# Traffic Impact Study

## Cloverleaf

El Paso County, CO

March 31, 2020

## School Pedestrian Routing to Lewis Palmer High School (0.2 miles)

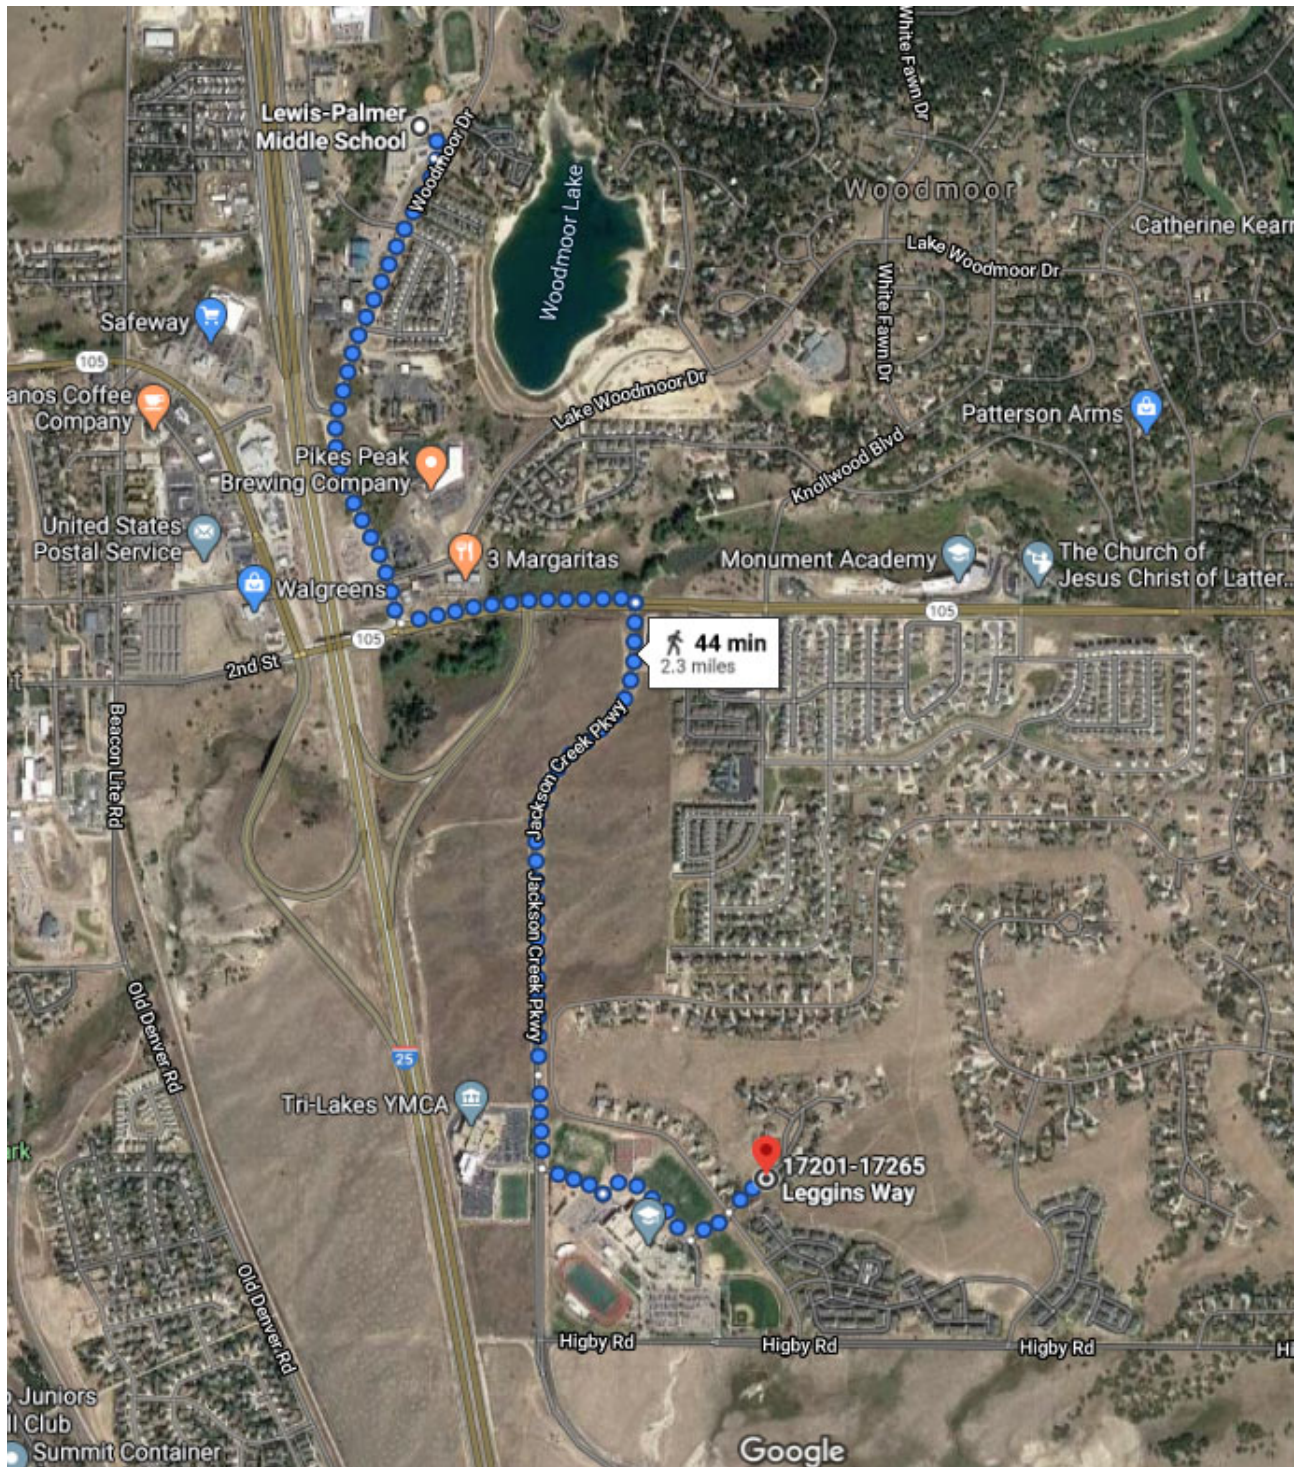
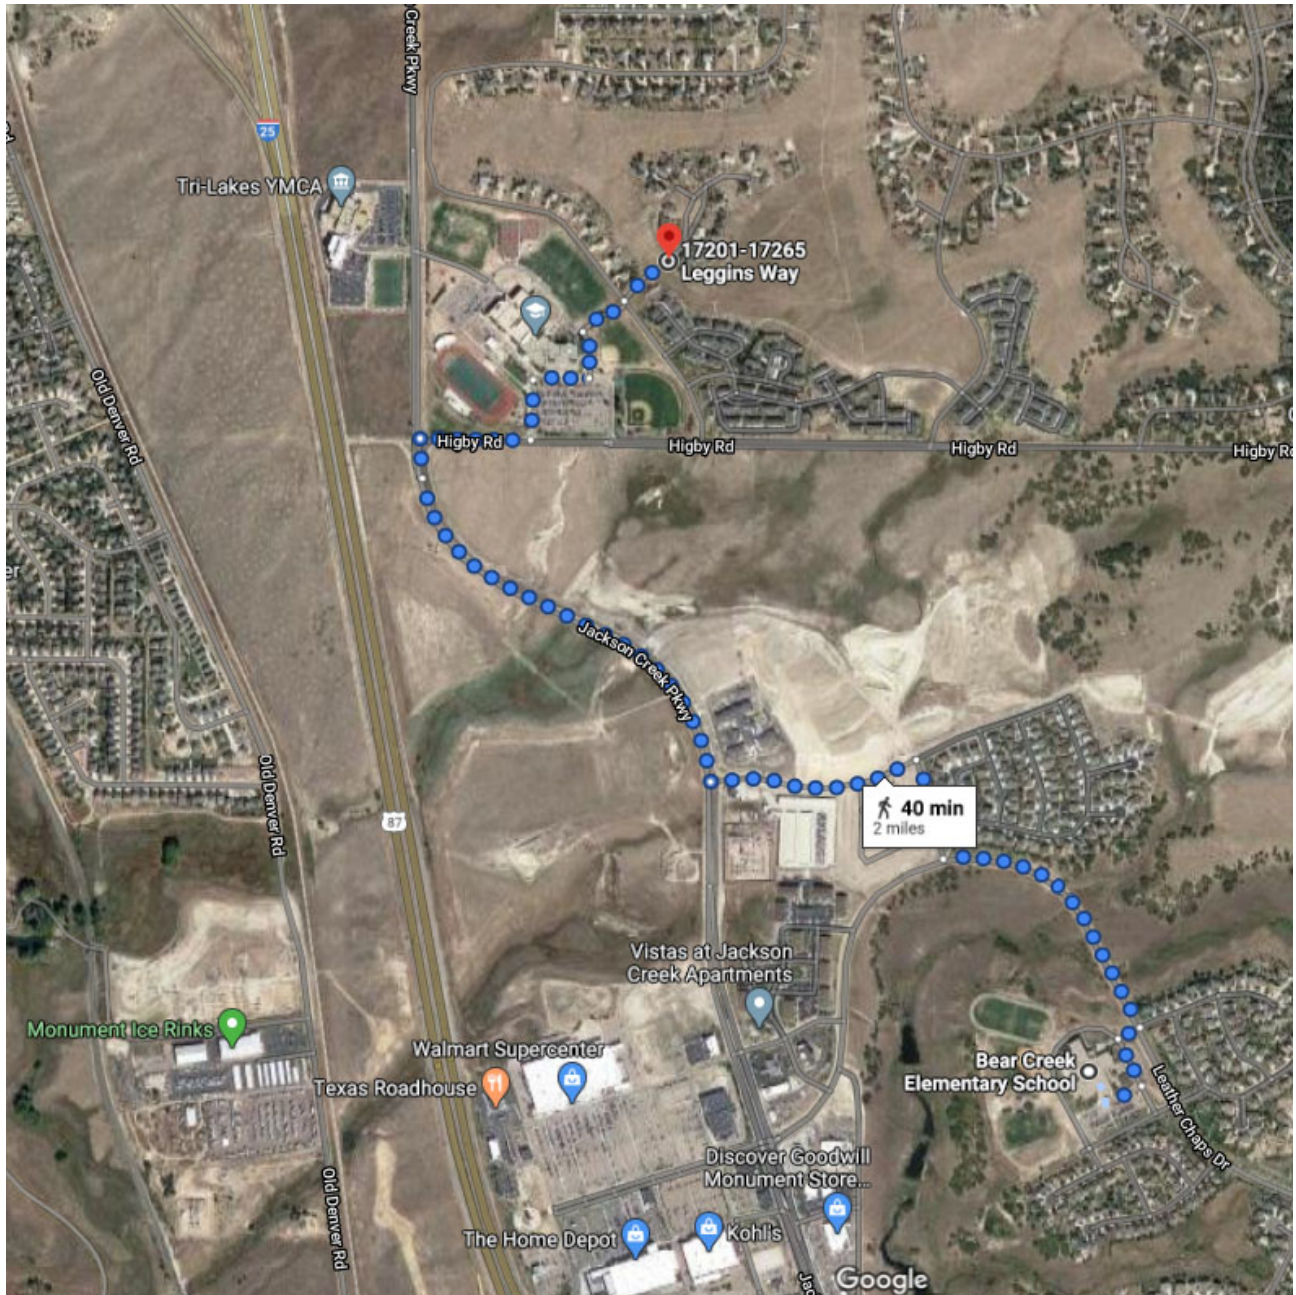
Add a section analyzing pedestrian routes to schools within 2 miles of the project (Lewis Palmer High School, Lewis Palmer Middle School, Bear Creek Elementary School) and recommendations for traffic control devices or on-site/off-site improvements. Include an exhibit showing school locations in the vicinity of the project.

Map 14: 2040 Functional Classification

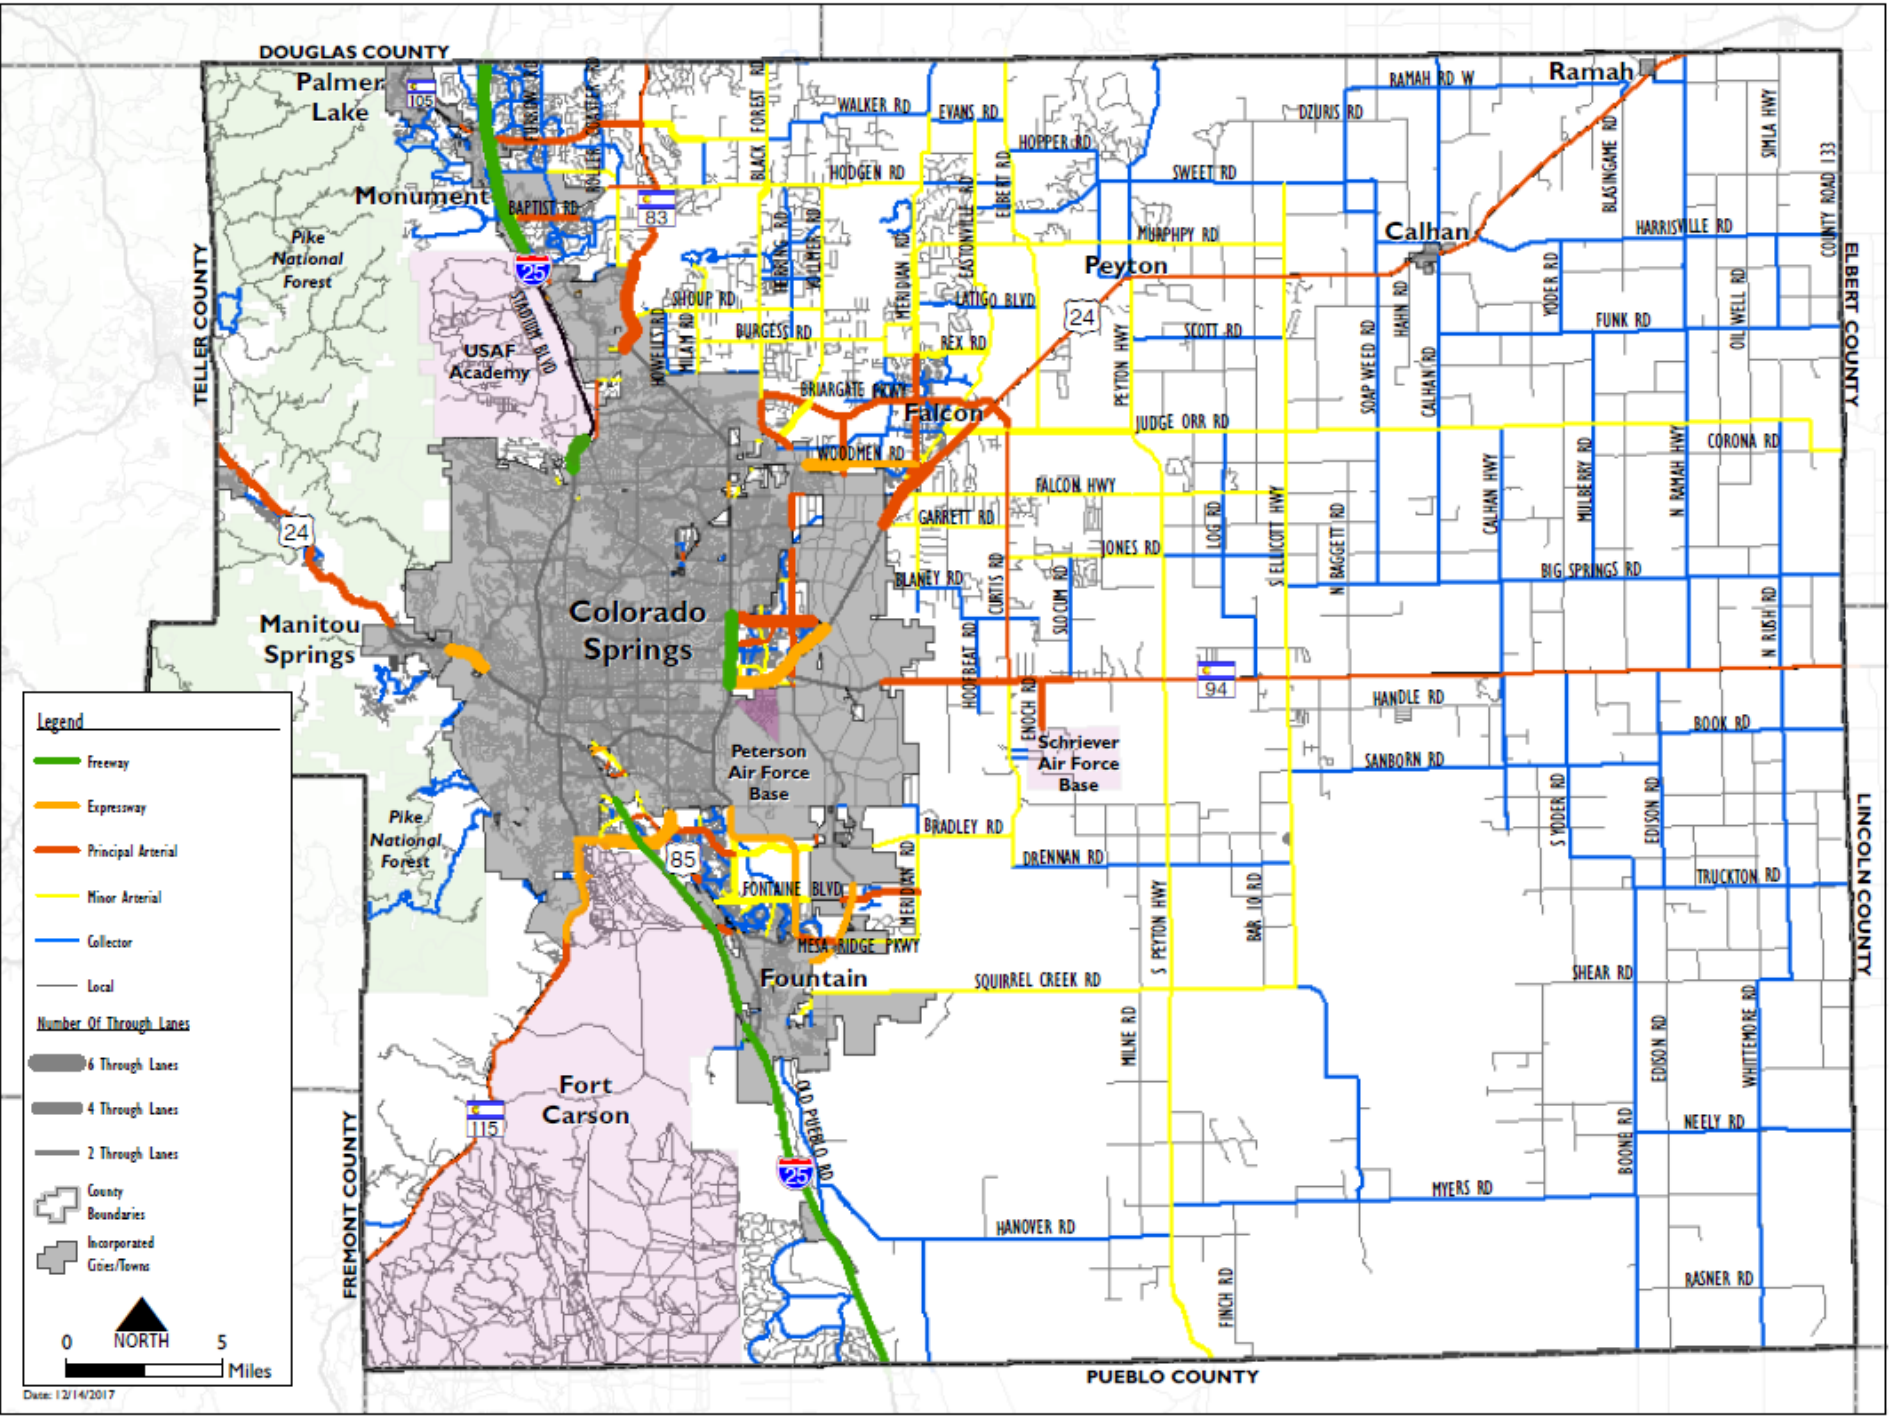
Update classification to standard county nomenclature by identifying "local" or "rural"

Appendix E: Sight Distance

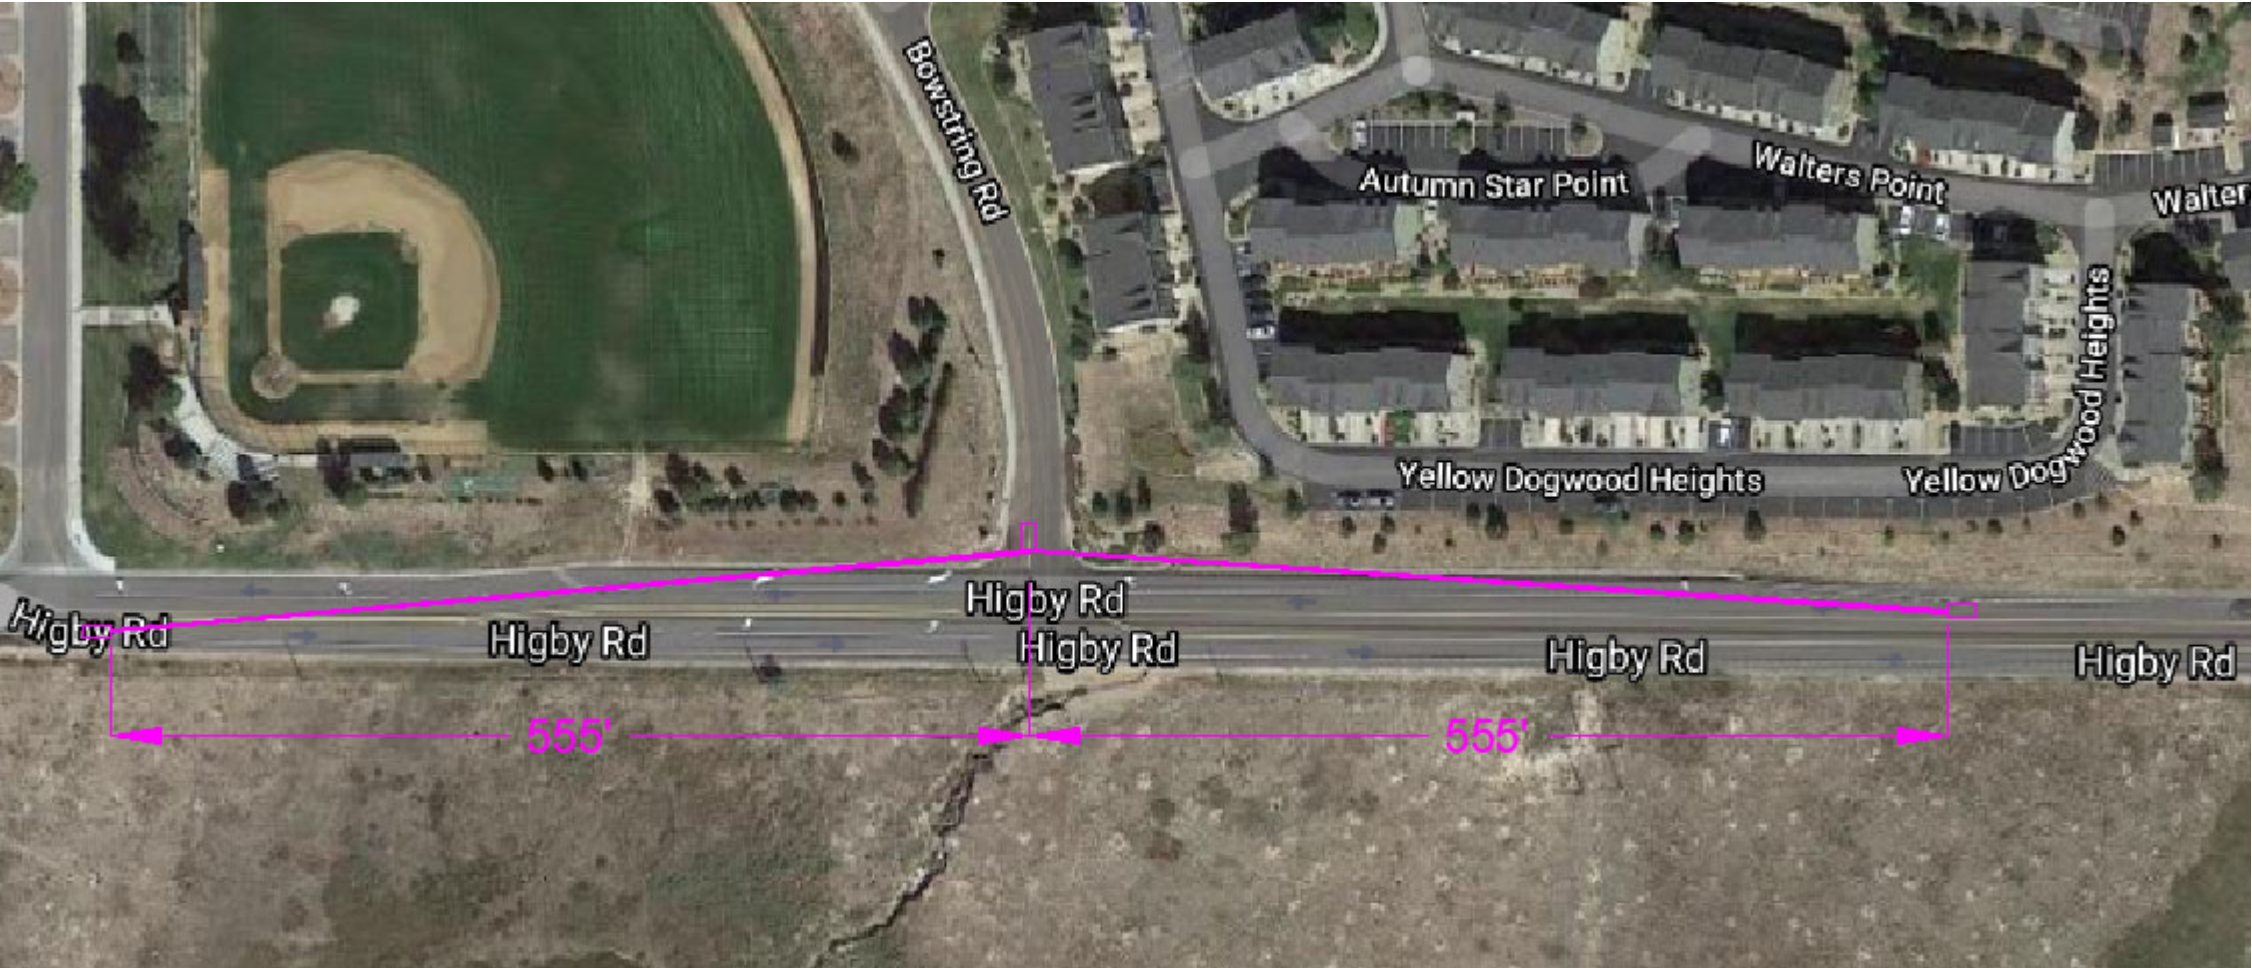
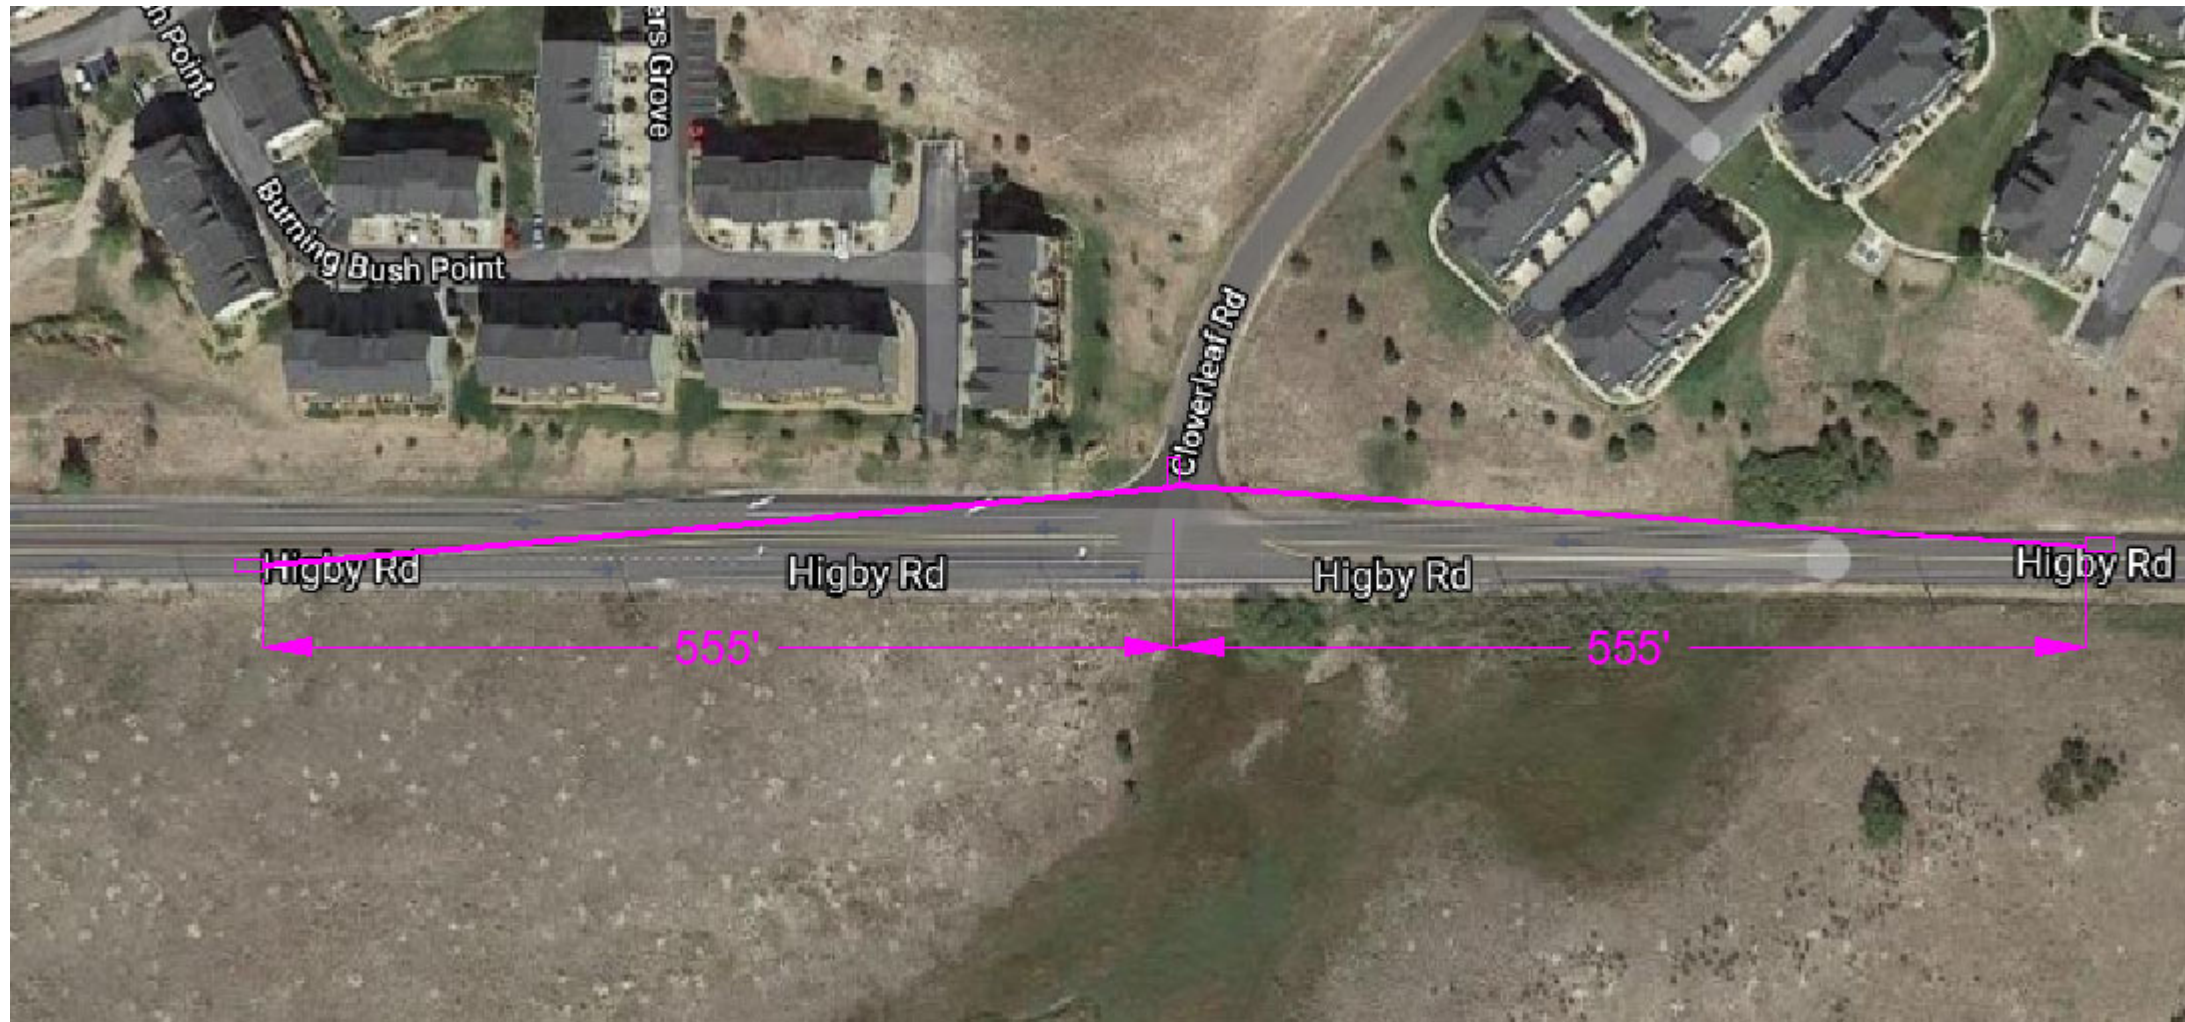
Add a section for sight distance analysis/recommendation at the proposed access locations. Include an exhibit showing the sight distance.
